MARKSHEFFEL CROSSING

EL PASO COUNTY SKETCH PLAN

MARKSHEFFEL CROSSING SKETCH PLAN

V2_Sketch Plan Drawing(s).pdf Markup Summary

MARKSHEFFEL CROSSING

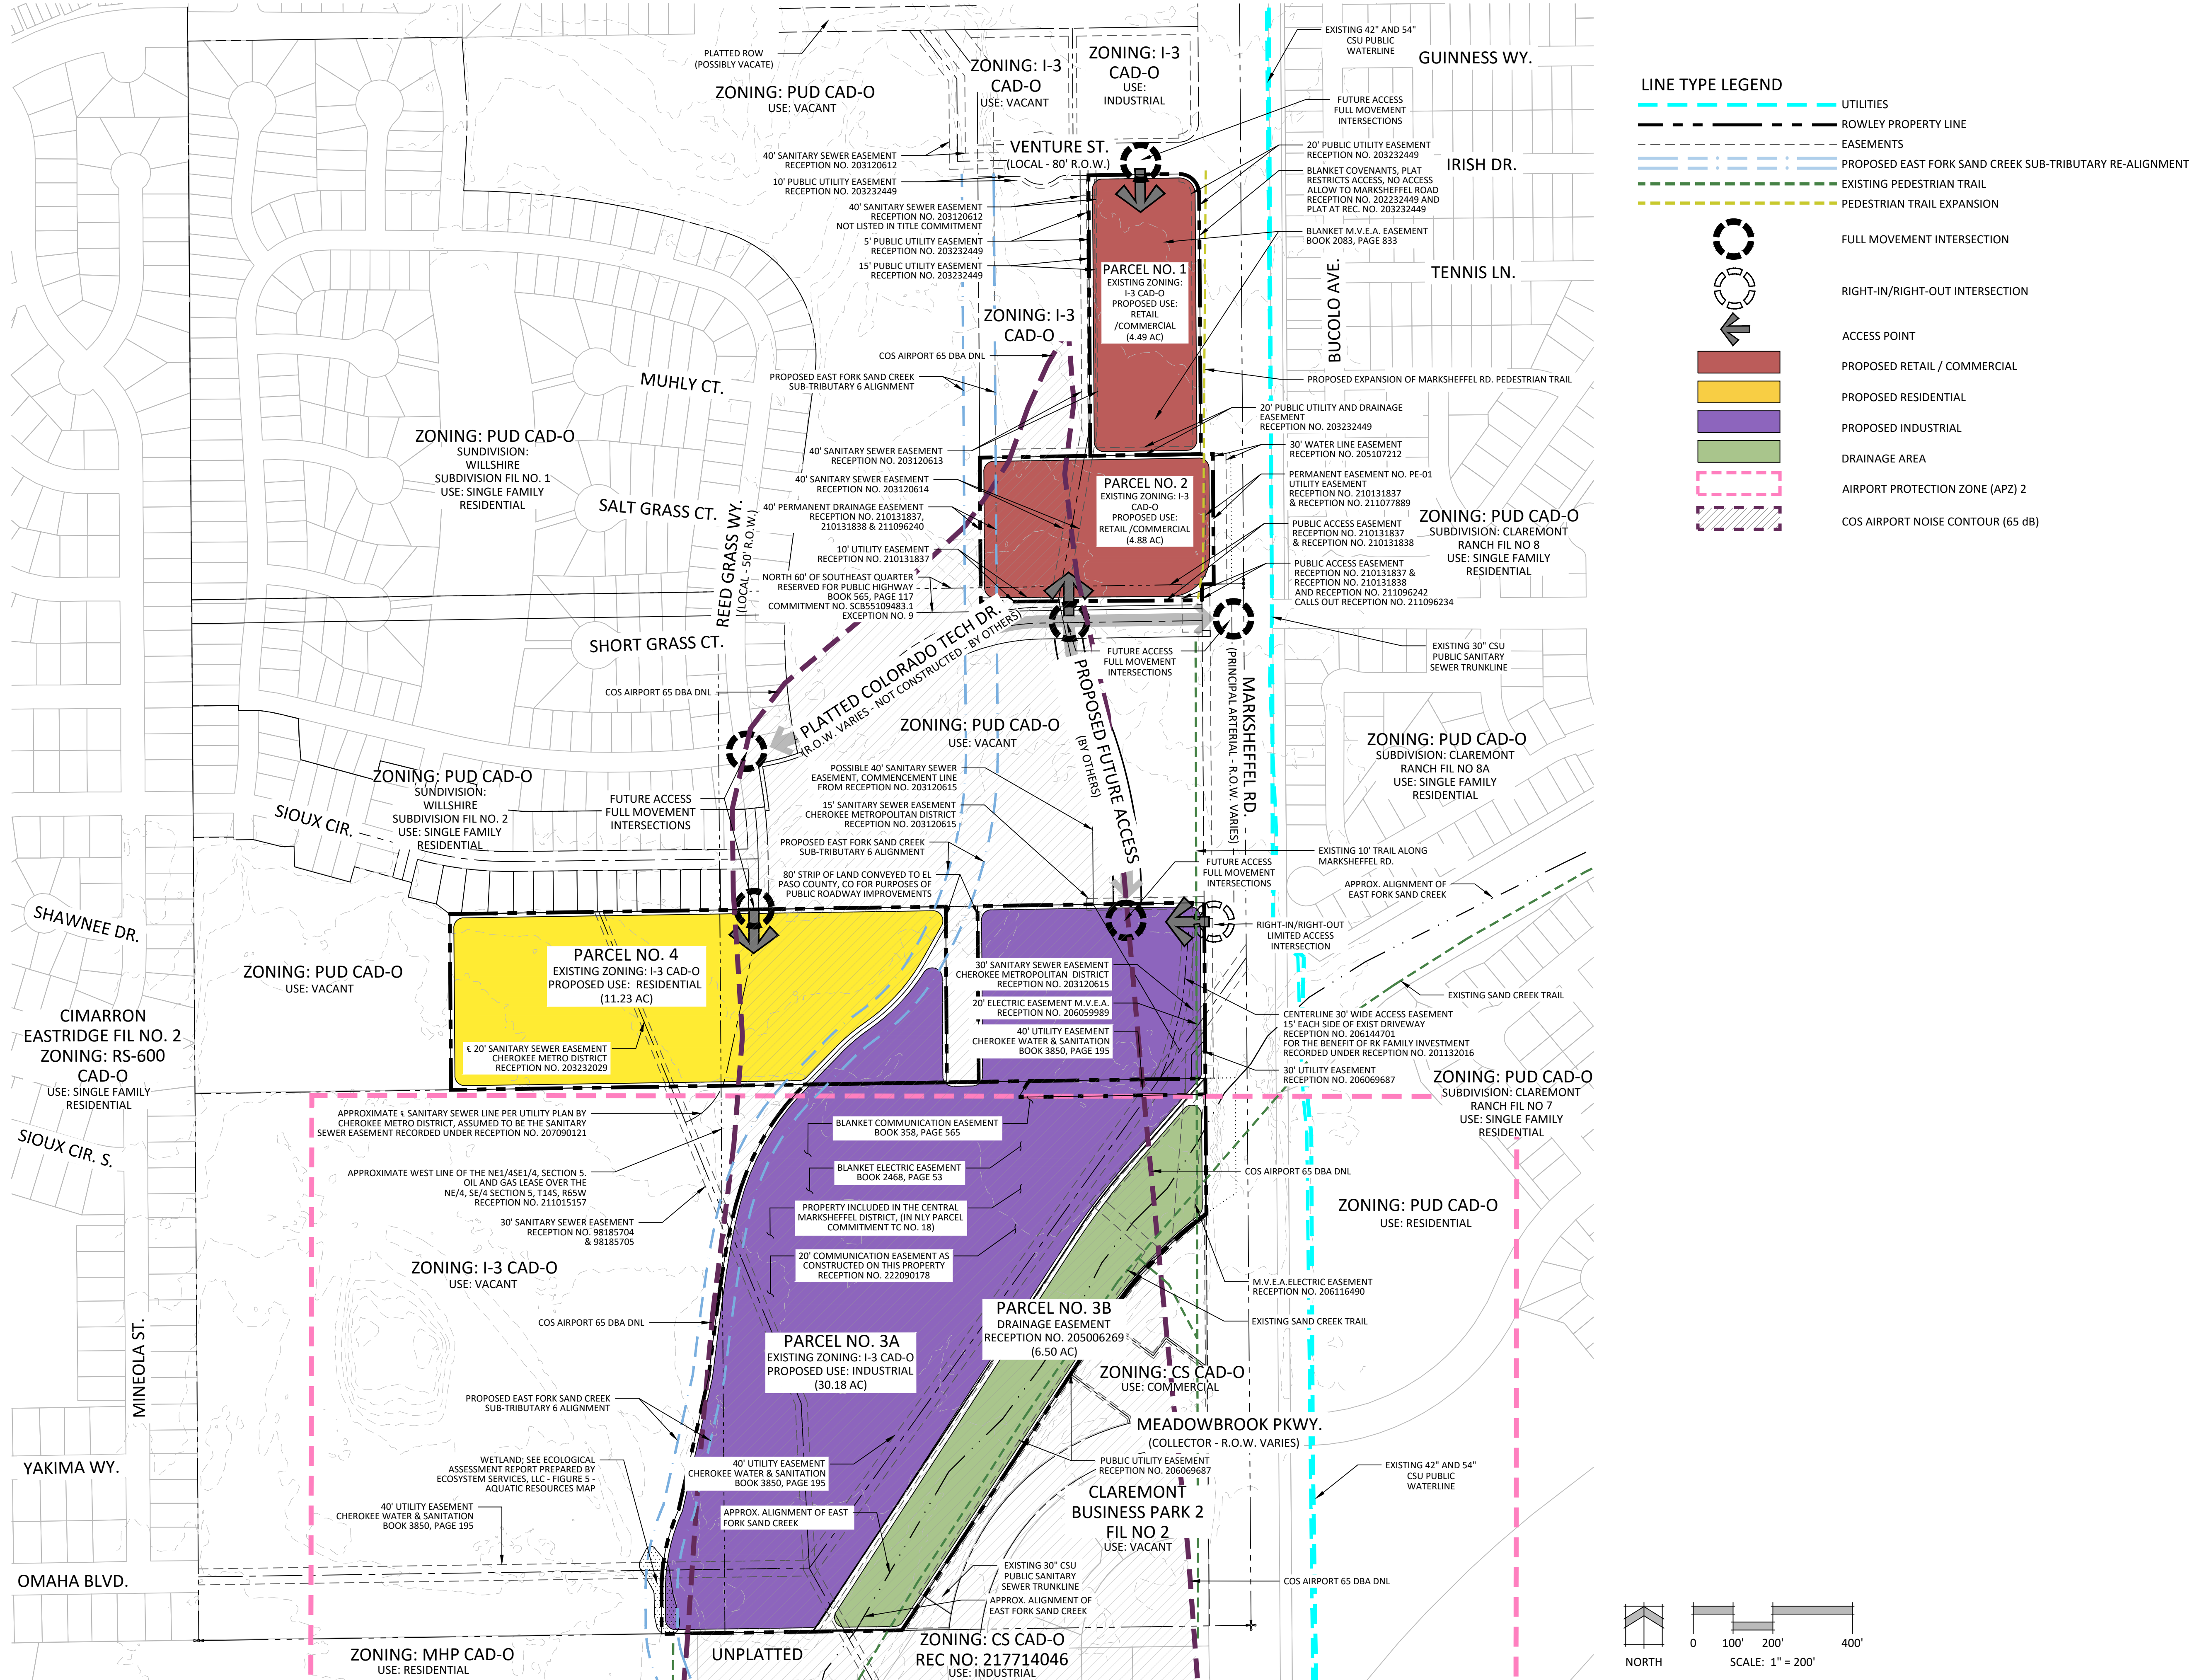
and 9/1/26

sheet flooding etc

Please add a descriptive note of the mitigation techniques to be utilized for the sound reduction for all land within the ADNL; Please reference the study identifying the appropriate mitigations for varying land uses

LINE TYPE LEGEND

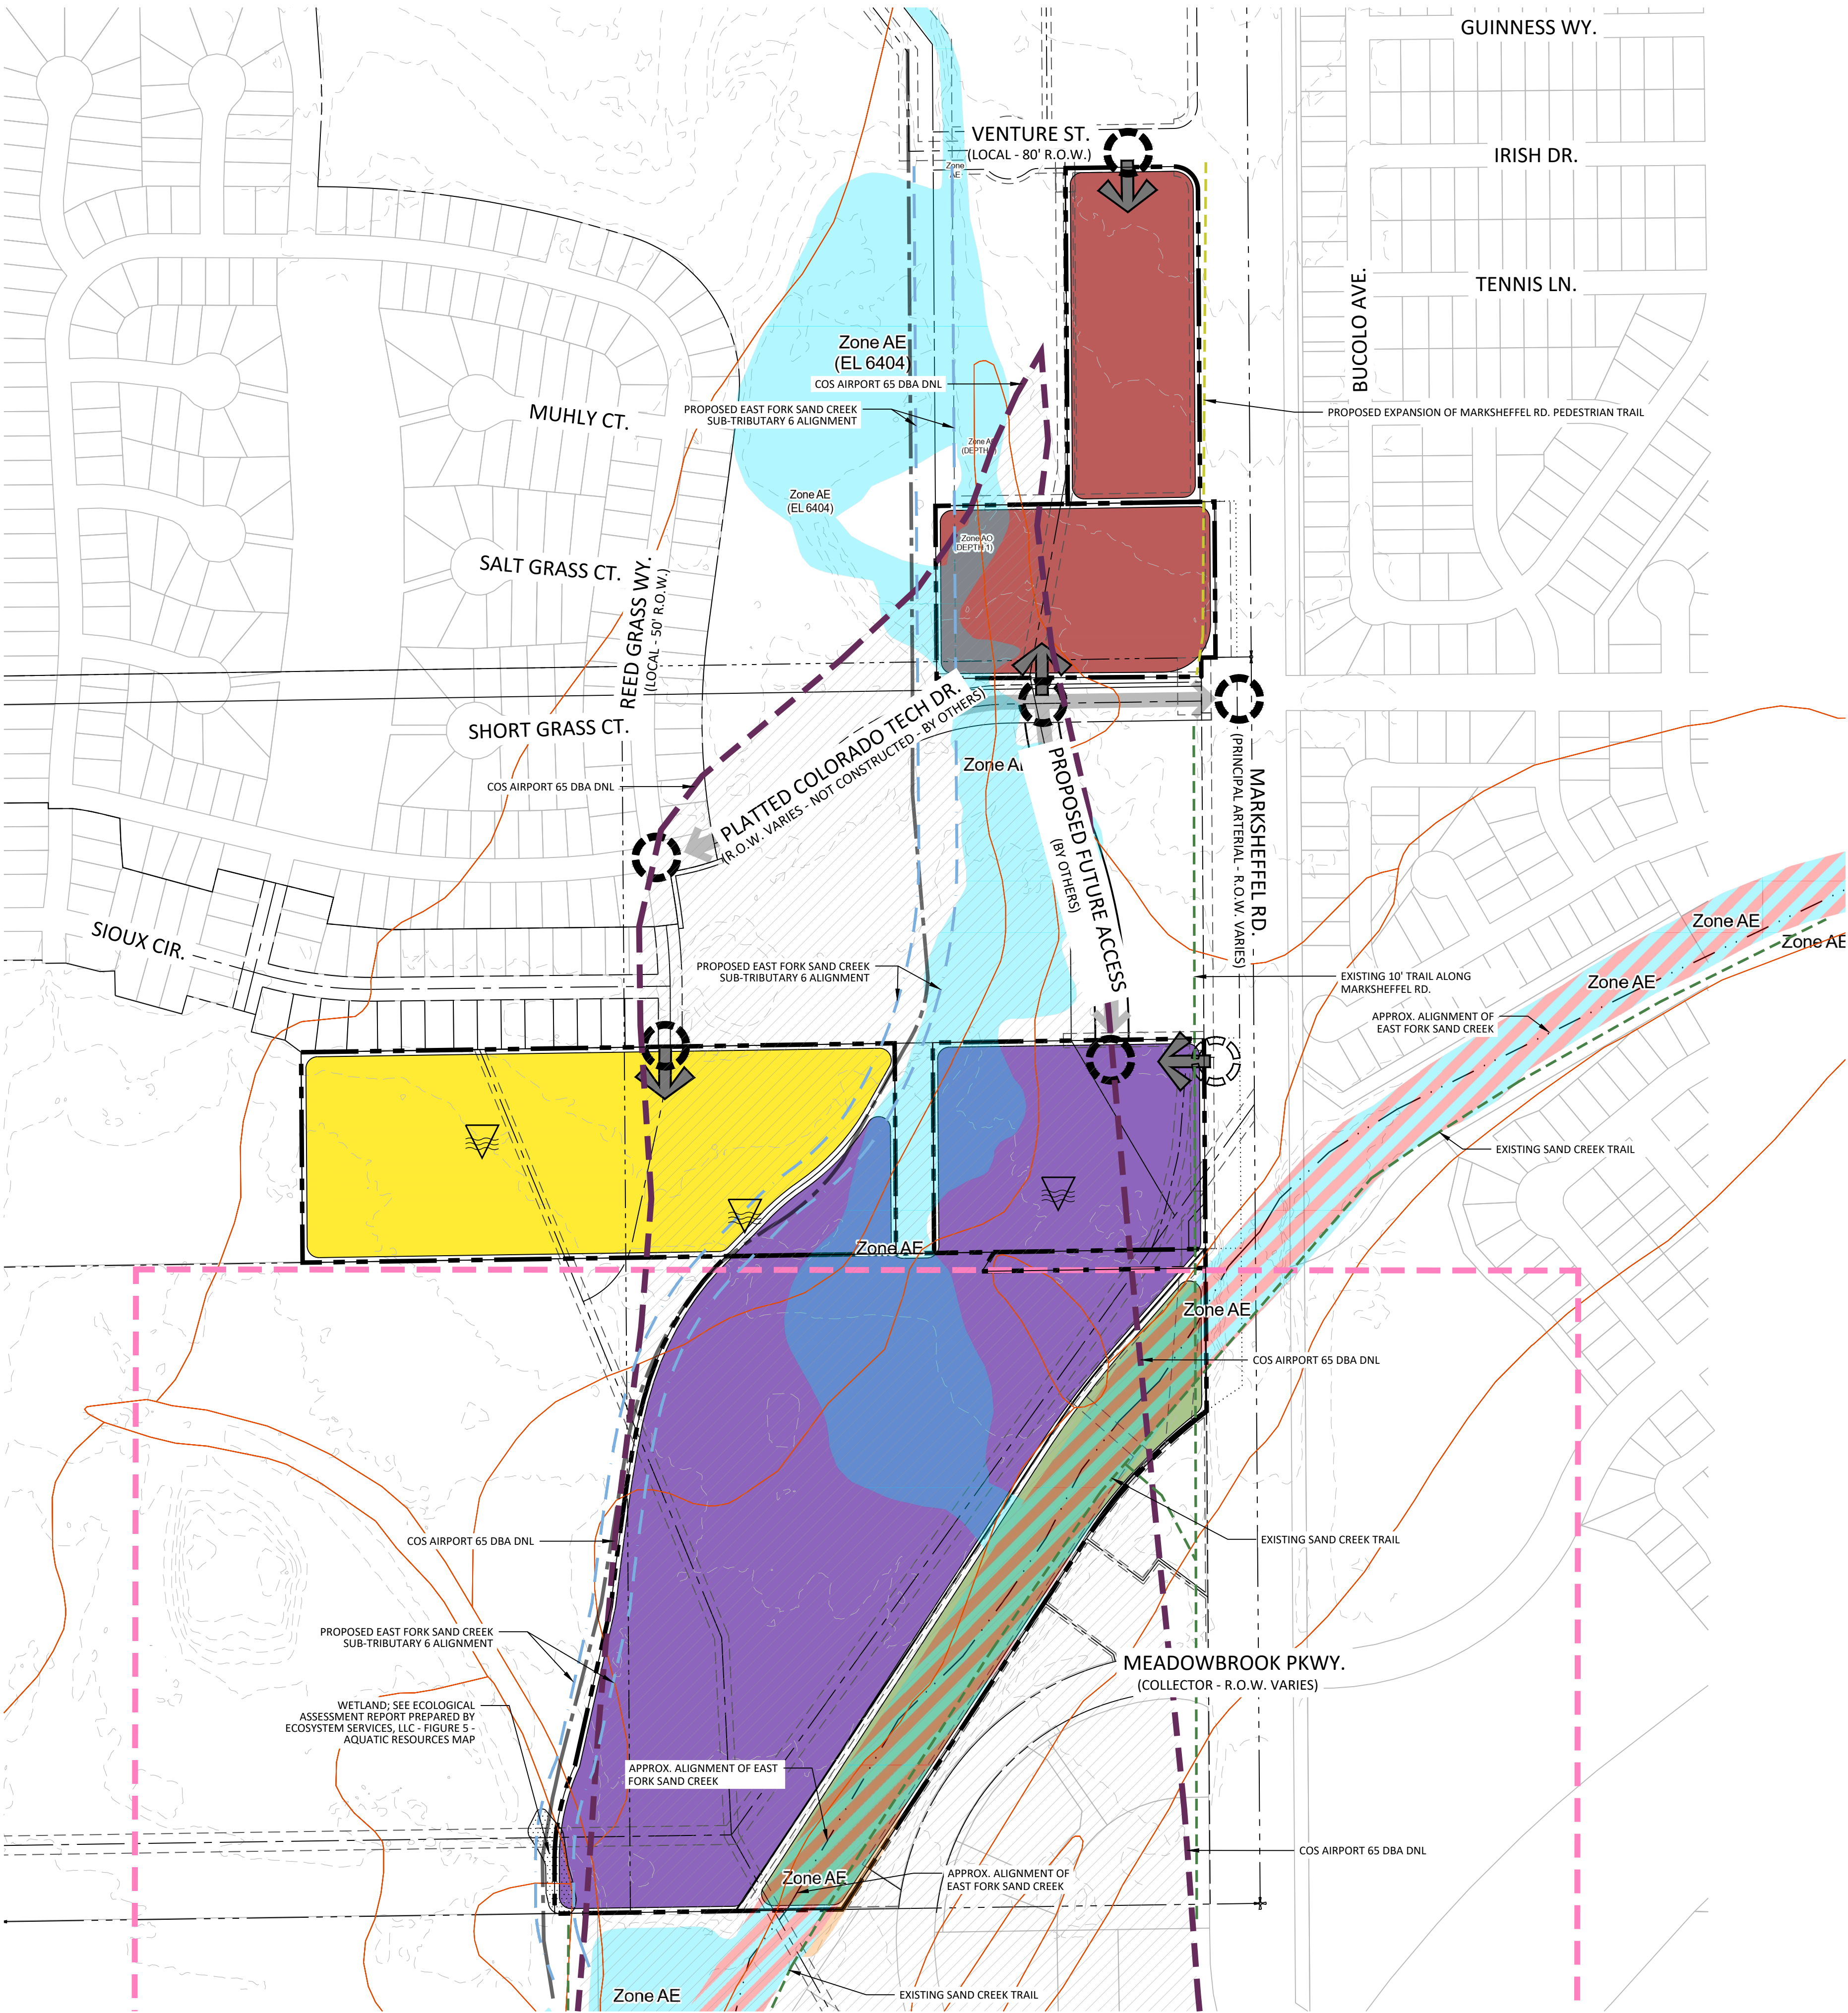
add update graphic and key

this is to broad- this linework could be anything...you have a sheet dedicated to this.

Add blue lines to legend

Non-residential collector?

Road classification?

Roadway connection for future land use per Code

Where did geologic soil area & FEMA floodplain analysis notes go from previous submittal?

ADJACENT PROPERTY OWNERS

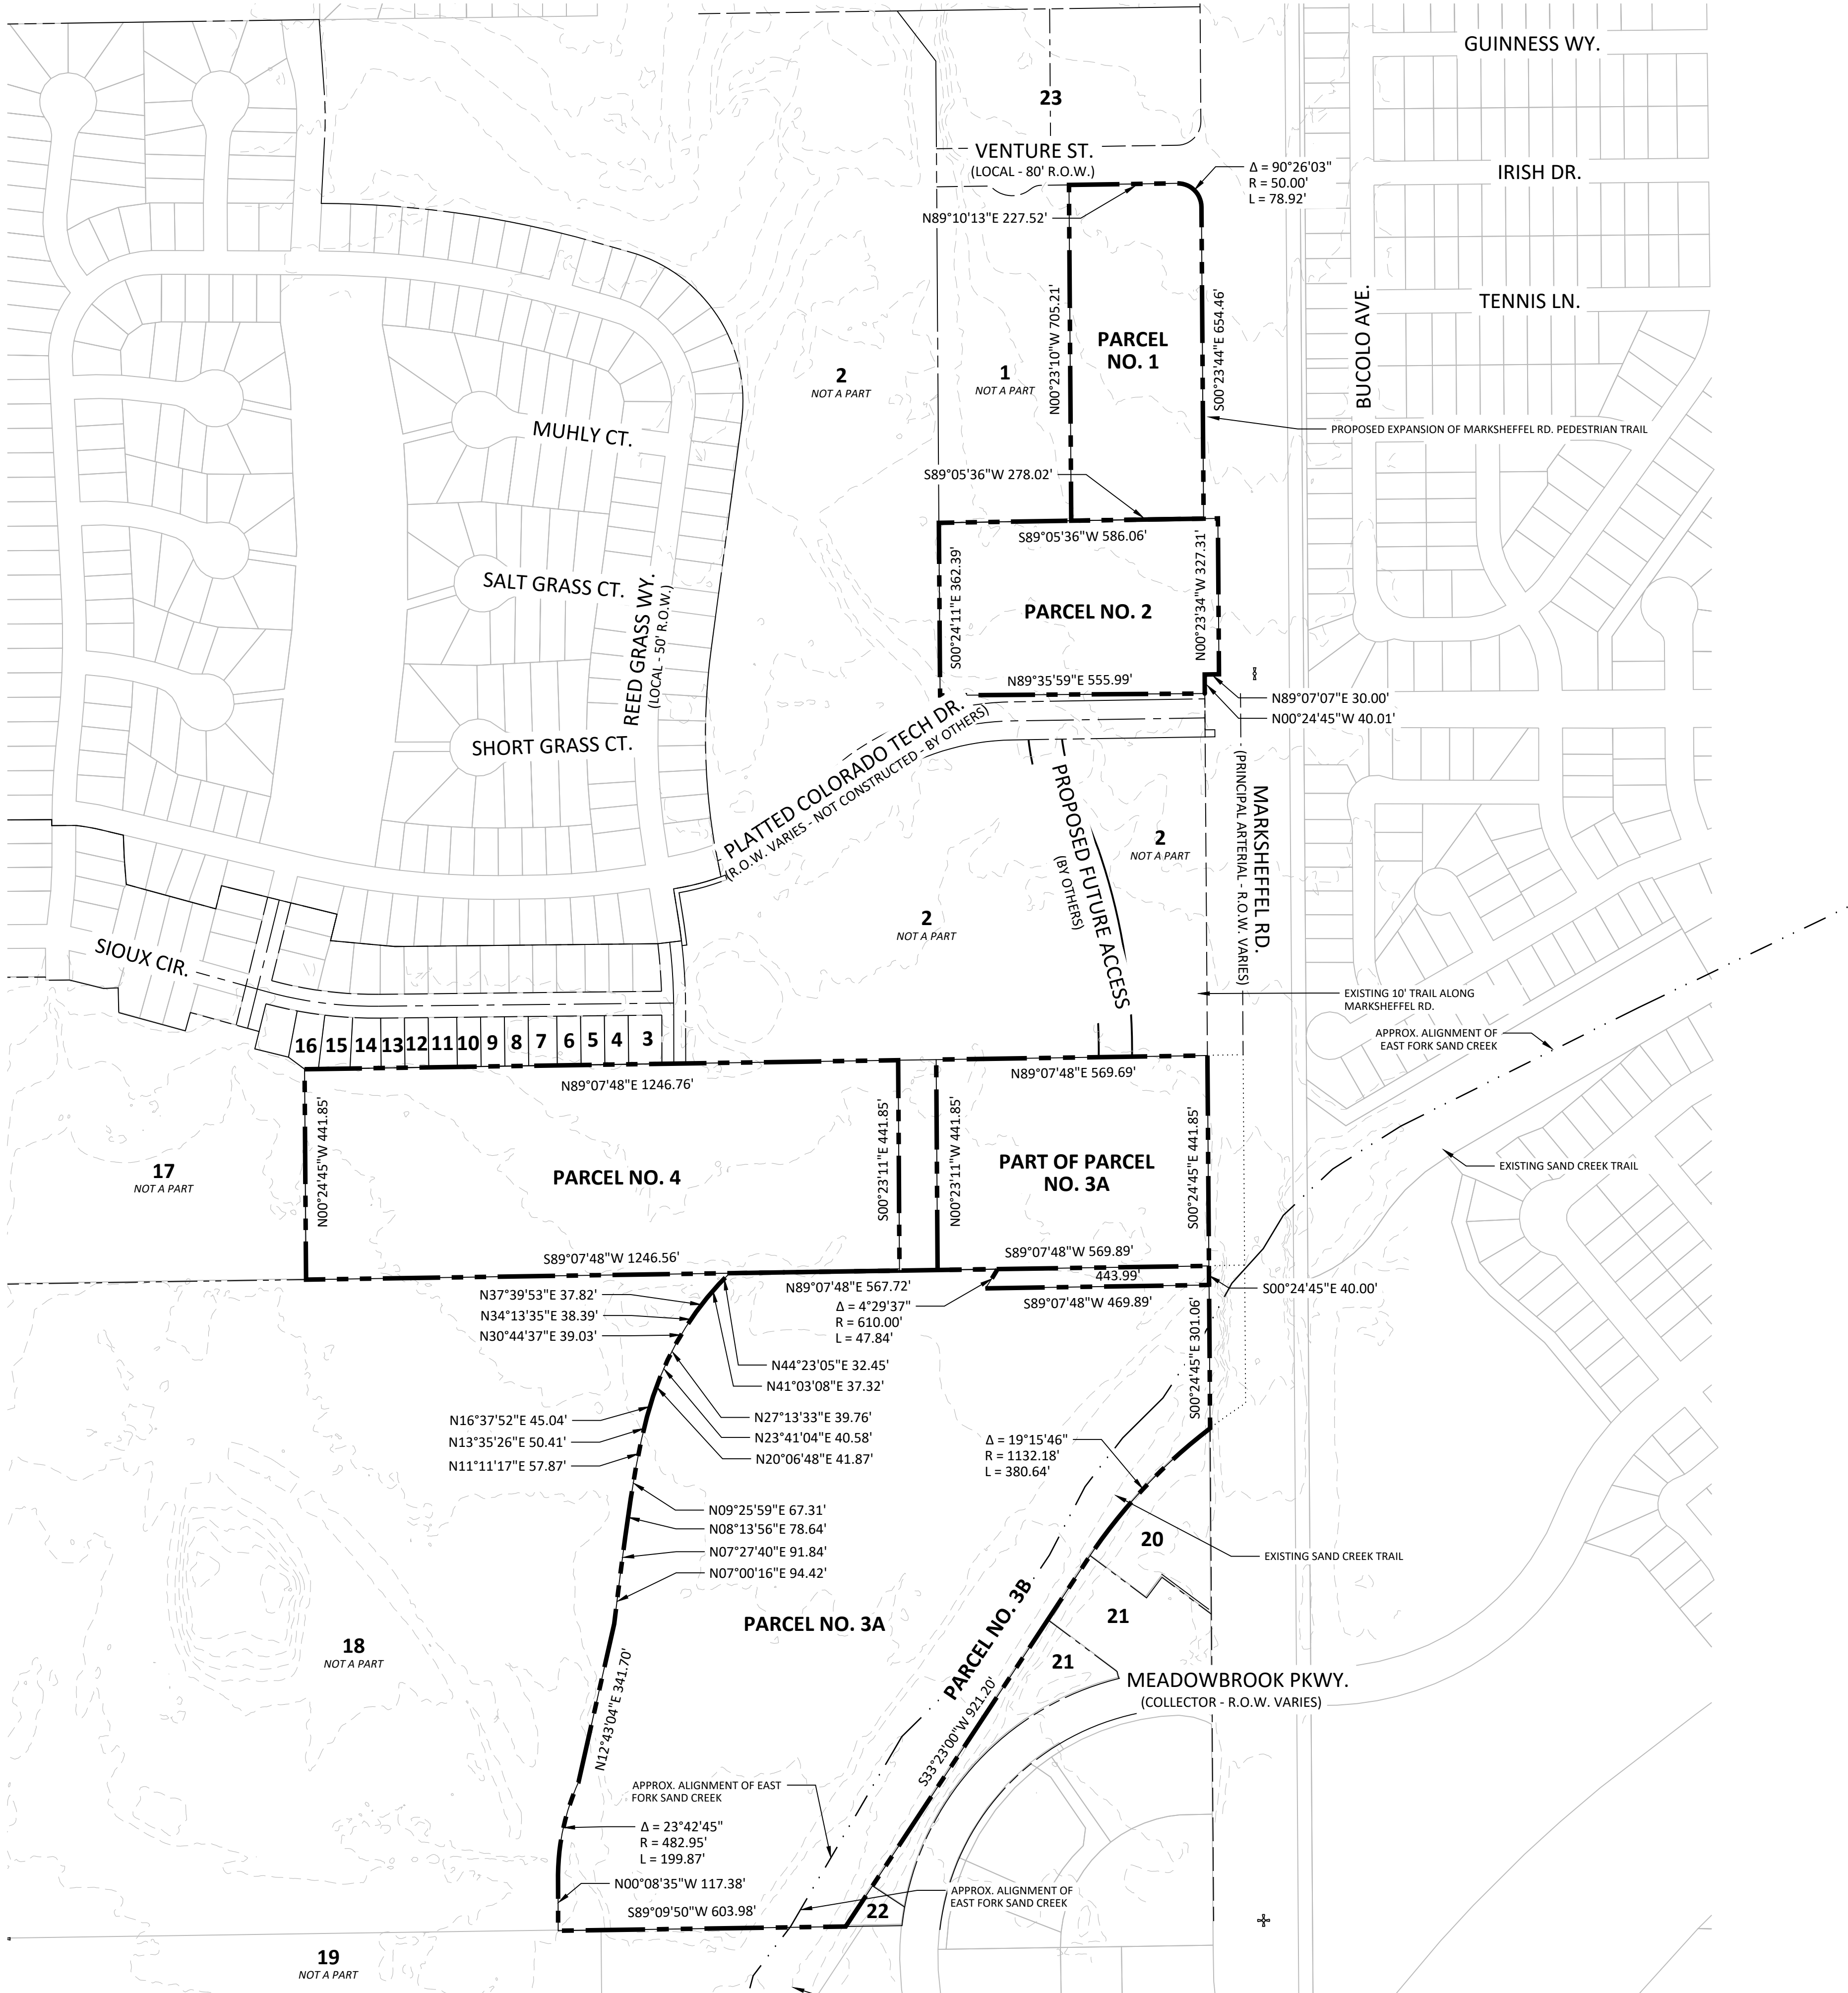
Label this parcel also (unknown / ROW?)

show trail

Provide classification for all roads
